CONSTRUCTION PLANS
FOR
SKYLINE AT LORSON RANCH FILING NO. 1
STREET AND STORM SEWER
CONSTRUCTION PLANS

SKYLINE AT LORSON RANCH FIL. NO. 1
STREET AND STORM SEWER
CONSTRUCTION PLANS

DATE: DEC 20, 2021
PROJECT NO. 100.063
SHEET NUMBER C0.1
TOTAL SHEETS: 18

## STREET AND STORM SEWER CONSTRUCTION PLANS

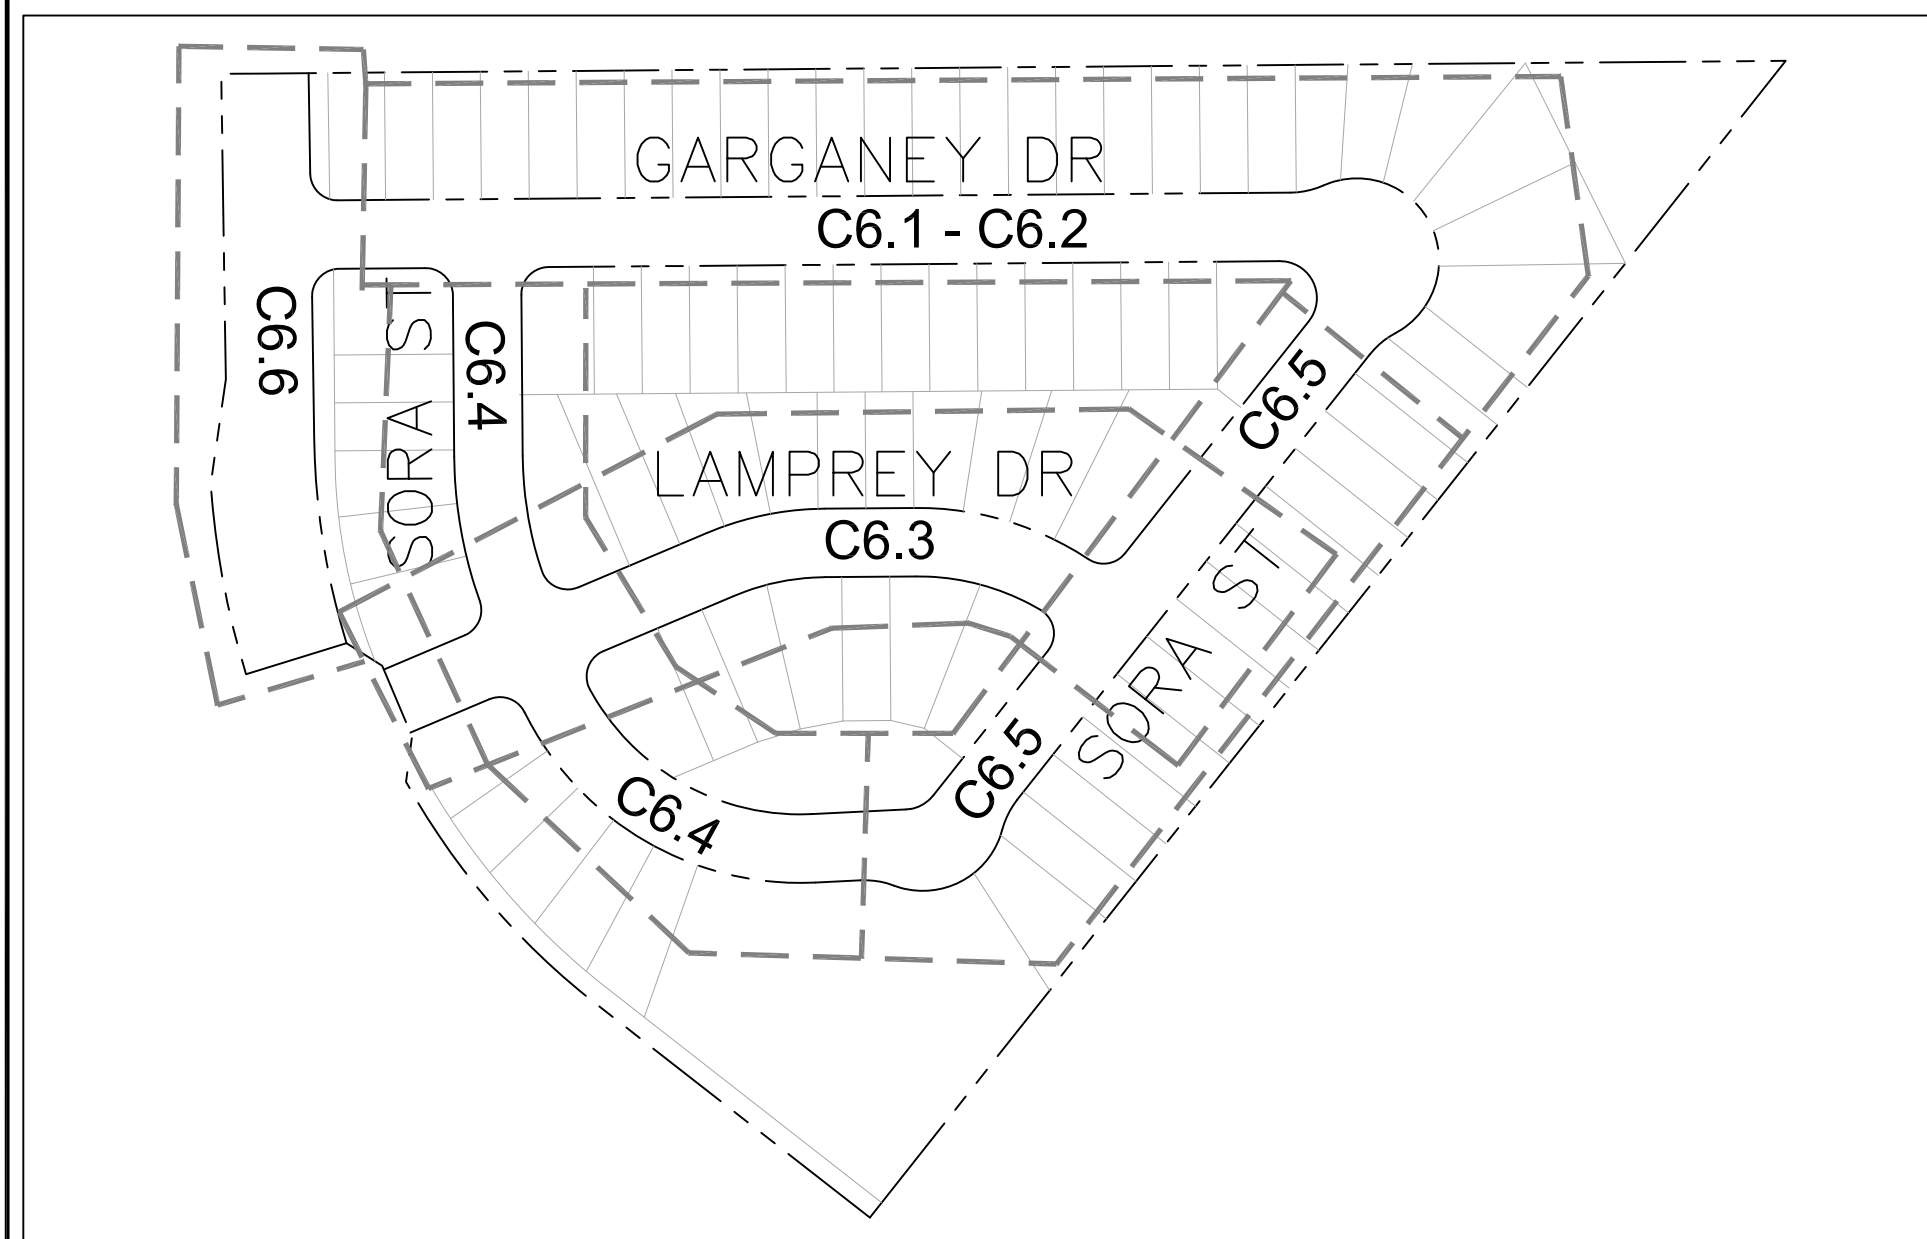
Sheet No's do not match

GARGANEY DRIVE

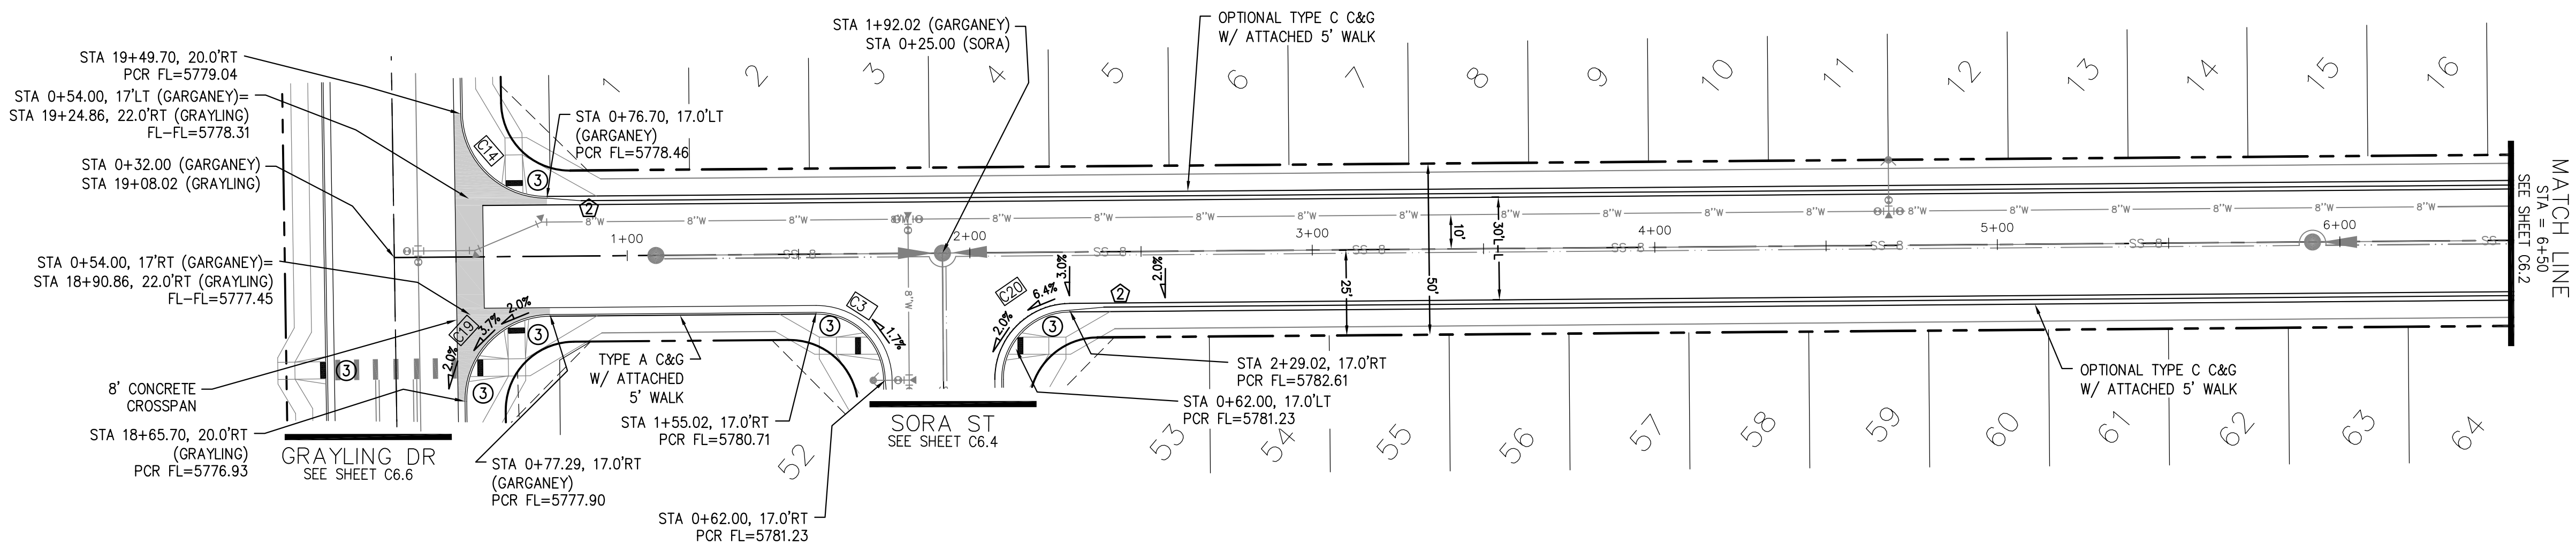
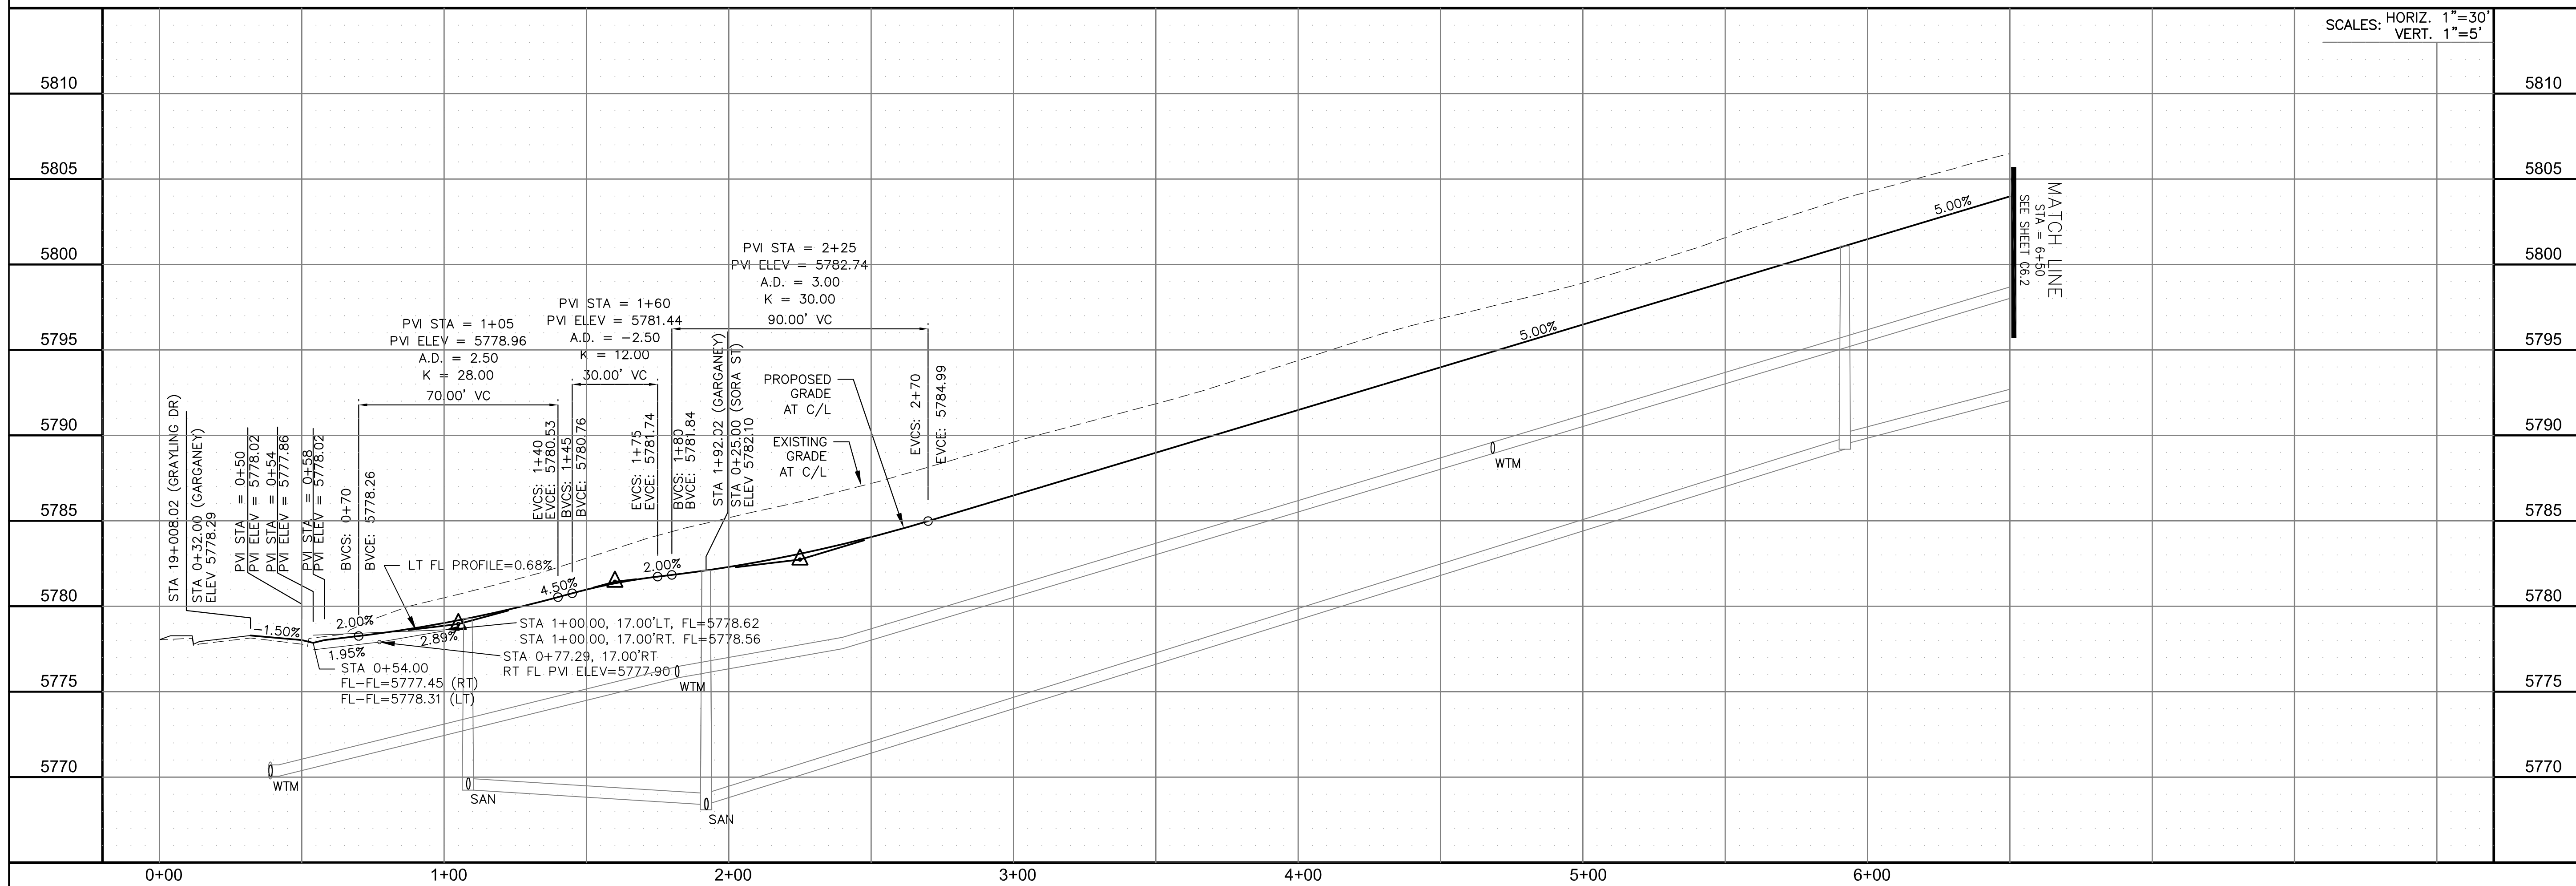
Include line information for alignment
line segments (all roadway sheets)

Include match lines in profiles
where needed (all roadway sheets)
